DRB Application No.: 06DRB-01257 (P&F)  
Project Name: MONTE VISTA SUBDIVISION  
Agent: George Rodriguez

Project # 1005109  
Phone No.: 610-0593

CITY OF ALBUQUERQUE  
PLANNING DEPARTMENT  
September 6, 2006  
DRB Comments

RE: Lots 3-5, Block 6, Monte Vista Subdivision/p&f

**PLAT OF
LOTS 3-A, 4-A, 4-B AND 5-A
BLOCK 6
MONTE VISTA SUBDIVISION**

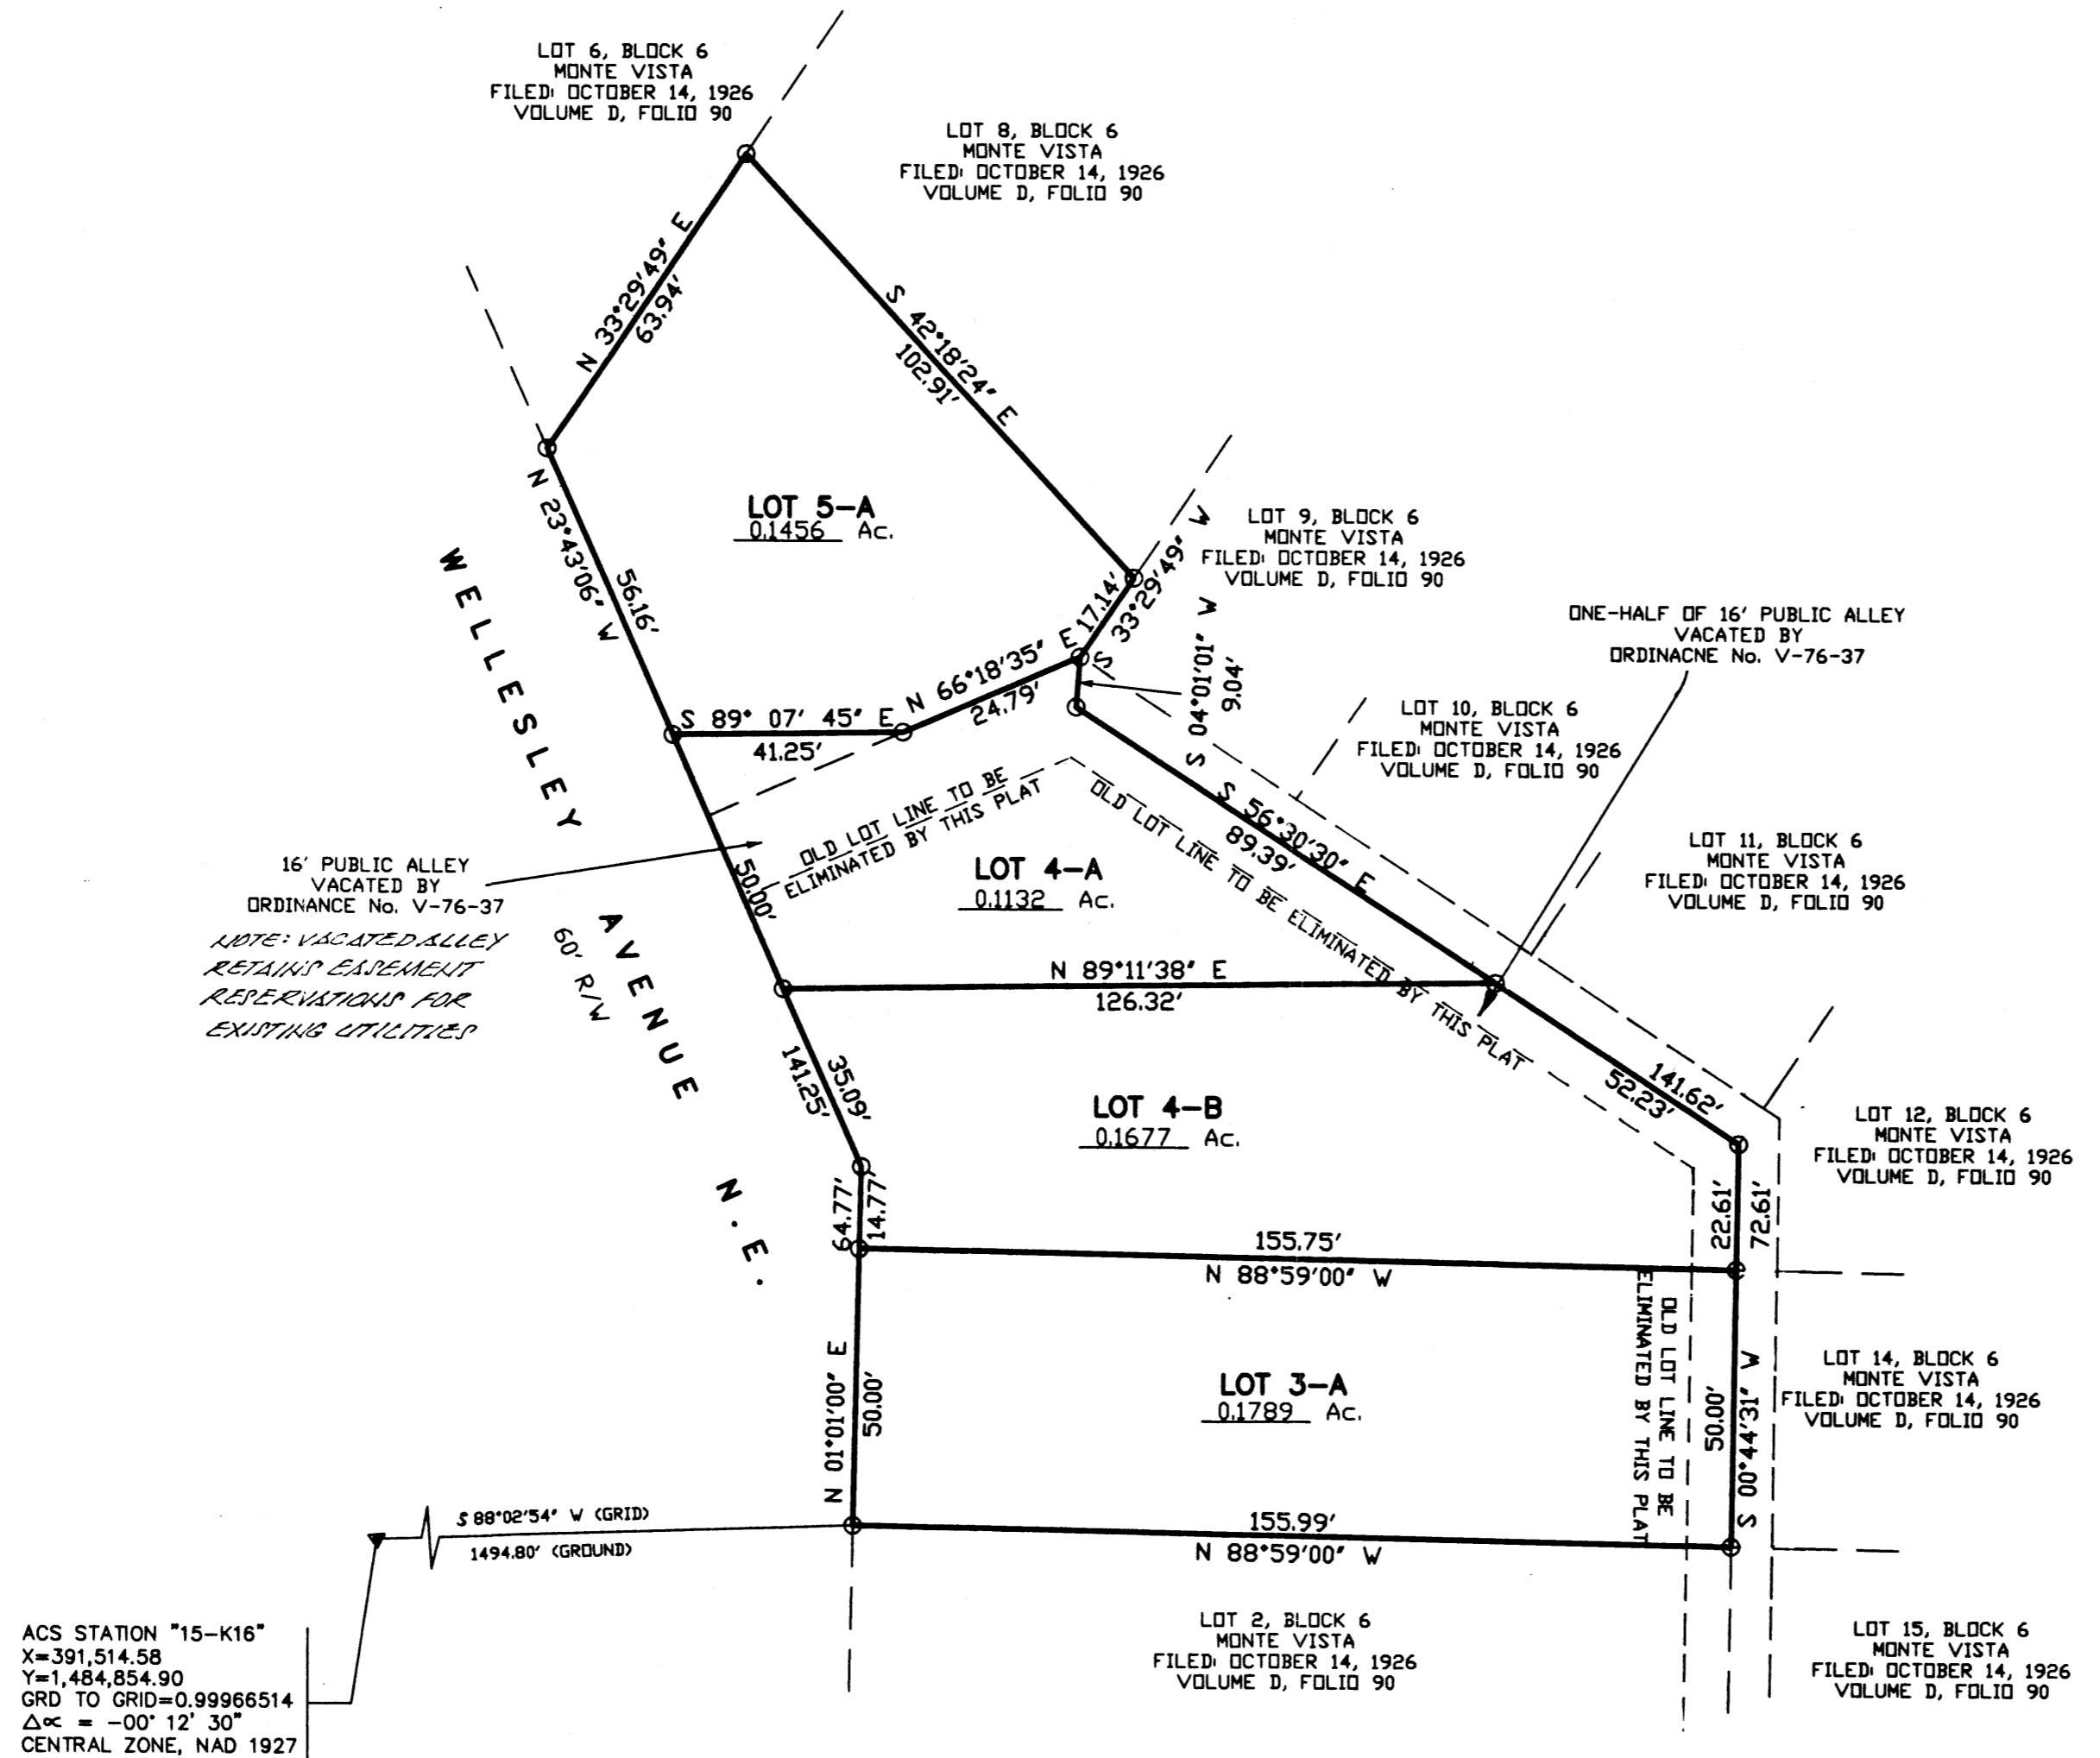
TRANSPORTATION: - WIDTH of STREET CURB TO CURB  
- LAYOUT of LOT 4-A

<u>No.</u>	<u>Comment</u>
1)	A copy of the vacation action is needed. Was the entire alley vacated?
2)	What is the width of the sidewalk?
3)	Has the structure on lot 4 been removed?
4)	How does the south driveway work with the new platting for lot 5-A?
5)	Should the new lots be P1 designated?
6)	The alley drive pad will need to be closed.
7)	Standard infrastructure per DPM is required.

AREA TABLE

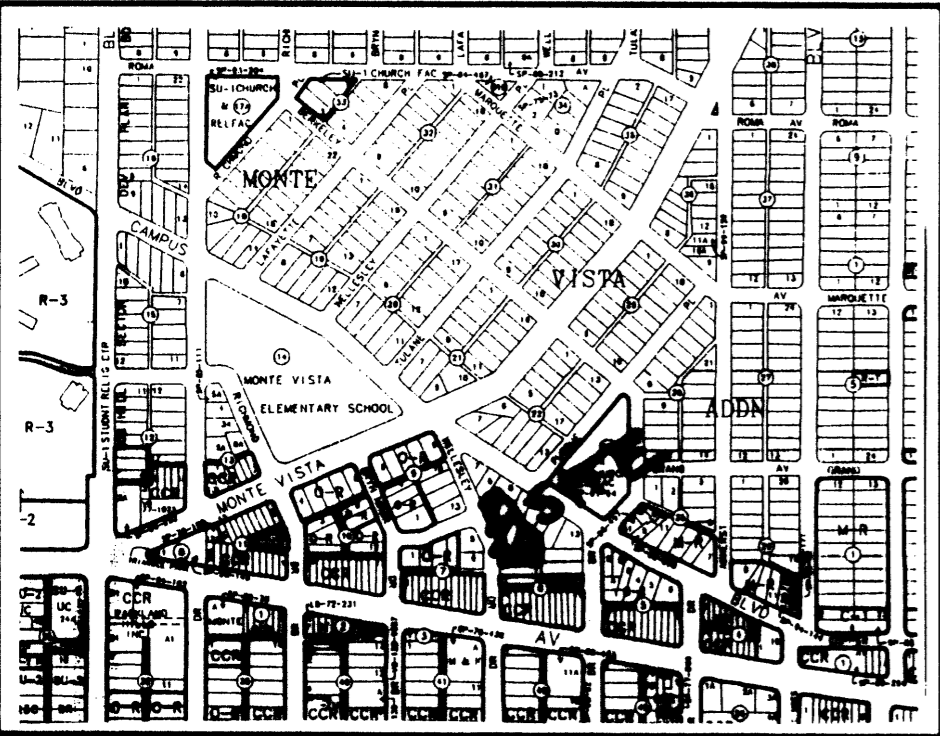
Lot 4-B lot size is less than the allowable square footage of the R-1 zone in the City Of Albuquerque Comprehensive Zoning Code.
